# SWPPP COMPLIANCE INSPECTION REPORT

Date of Inspection	Tuesday, August 3, 2021
Project	7200 Bluewater NW
Location	SW corner of Airport Rd and Bluewater Rd

NPDES #	NMR 1003UT and NMR 1003WM
Permit Type	Construction General Permit and LEW
Inspection Type	SWPPP Compliance Inspection- 14 day or >.25"

ENGINEER'S SEAL RONALD R. BOHANNAN P.E. #7868	7200 BLUEWATER RD ALBUQUERQUE, NM	DRAWN BY pm
		DATE 8-4-21
	EROSION CONTROL PLAN	DRAWING 2020056-SWPPP
	TERRA WEST, LLC 5571 MIDWAY PARK PL NE ALBUQUERQUE, NEW MEXICO 87109 (505) 858-3100 www.tierrawestllc.com	SHEET # SW-1 JOB # 2020056

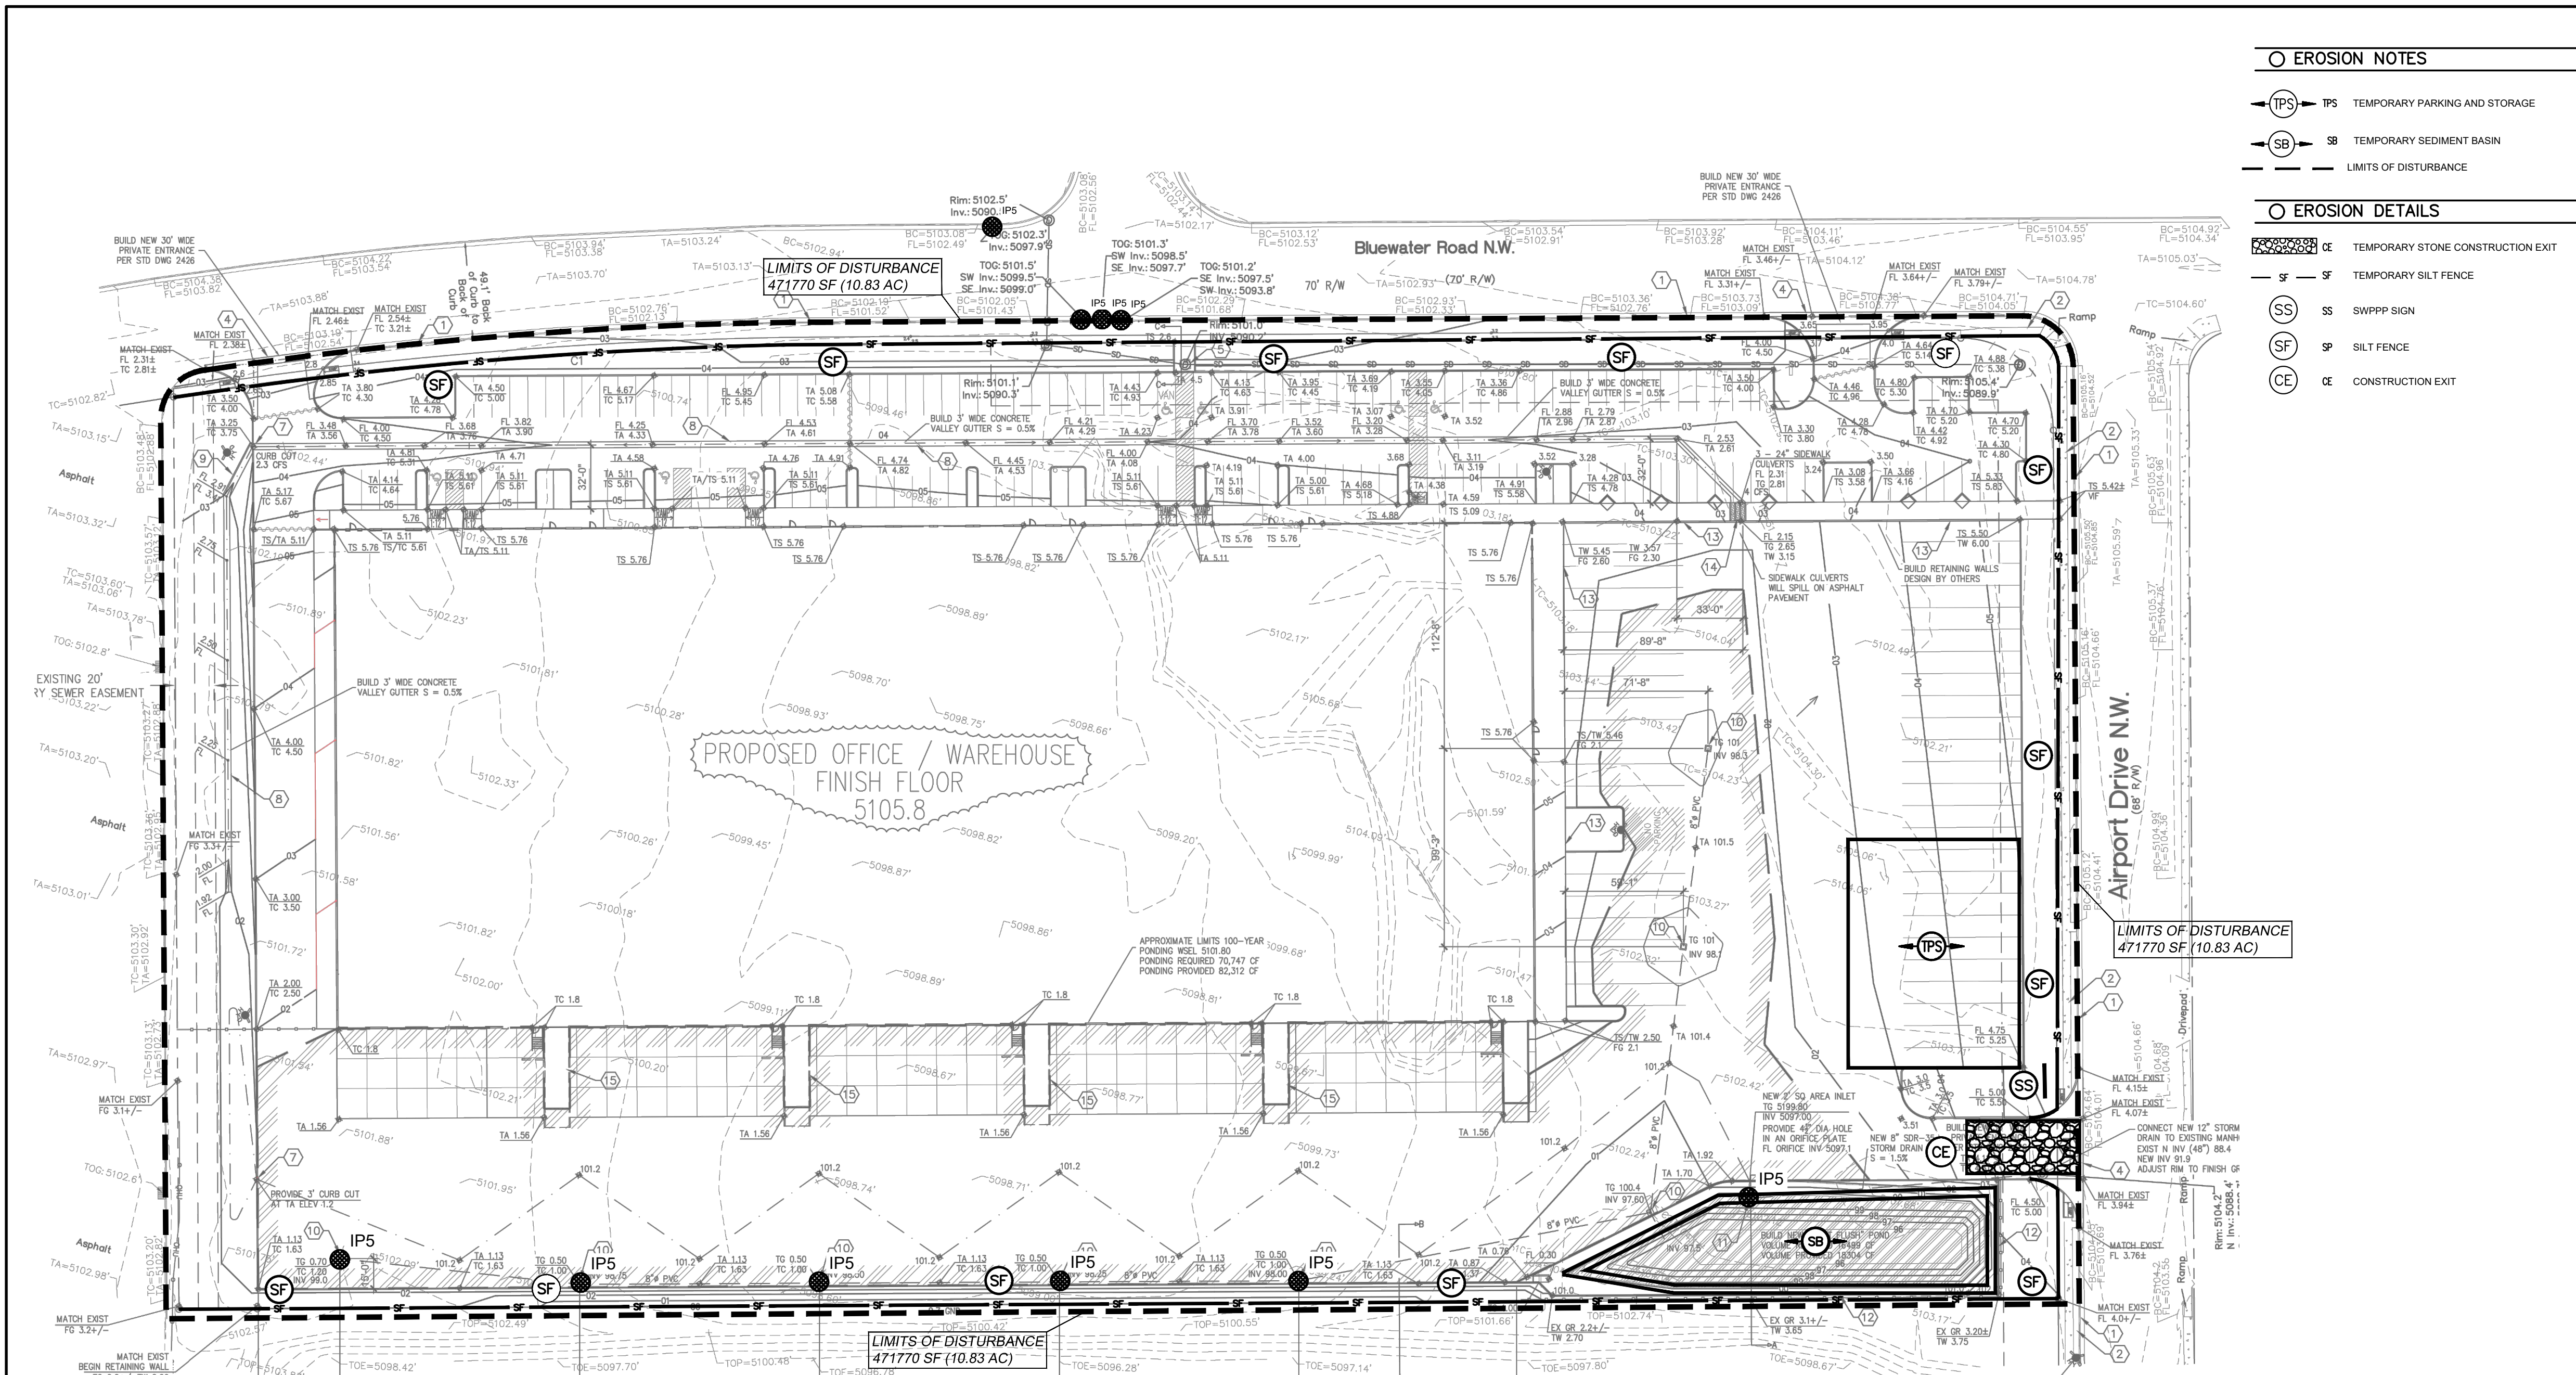
SITE INSPECTION OBSERVATIONS			
SWPPP Item	Yes/No/NA	Action Required	Notes:
Is the SWPPP Notice properly posted with correct information?	No	Post NMR #'s on E2RC Board	Correct #'s are : NMR1001YX, NMR10044I- LEW Site NMR1003WM
Are the Limits of Disturbance properly protected?	No	Repair silt fencing on Bluewater Rd	Damaged by offsite motor vehicle accident
Are all Natural Resources or boundary with the Waters of The United States properly protected with barriers or BMP's?	N/A	None	
Are Construction Exits properly controlling sediment track out from the site?	No	Extend exit and add rock. Sweep track out	Track out was observed.
Are all Discharge Points and Offsite Flows properly controlled?	Yes	None	
Are all Channels, Spillways or Emergency Overflows protected?	N/A	None	
Are Inlets and Water Quality Device properly protected from sediment?	No	Re-position inlet waddles on Airport Rd control sediment form entering inlet	Inlet protection was damaged by offsite vehicle accident

Is the site in compliance with EPA or NPDES Permit Indicated?	No	Fix silt fencing as noted, post permit #'s and re-position inlet controls on Airtort	Compliance would be indicated with completion of the noted items

Control	Location	Issue	Maintenance or Corrective Action?
Inlet	Bluewater Rd	Controls	Re-position wattles to control sediment
Sign	Entrance/ Exit	Post correct permit #'S	On E2RC Board
Entrance	Airport Rd	Track out	Sweep roadway/ add rock
Silt Fencing	Bluewater Rd	Damaged	Repair silt fencing due to accident
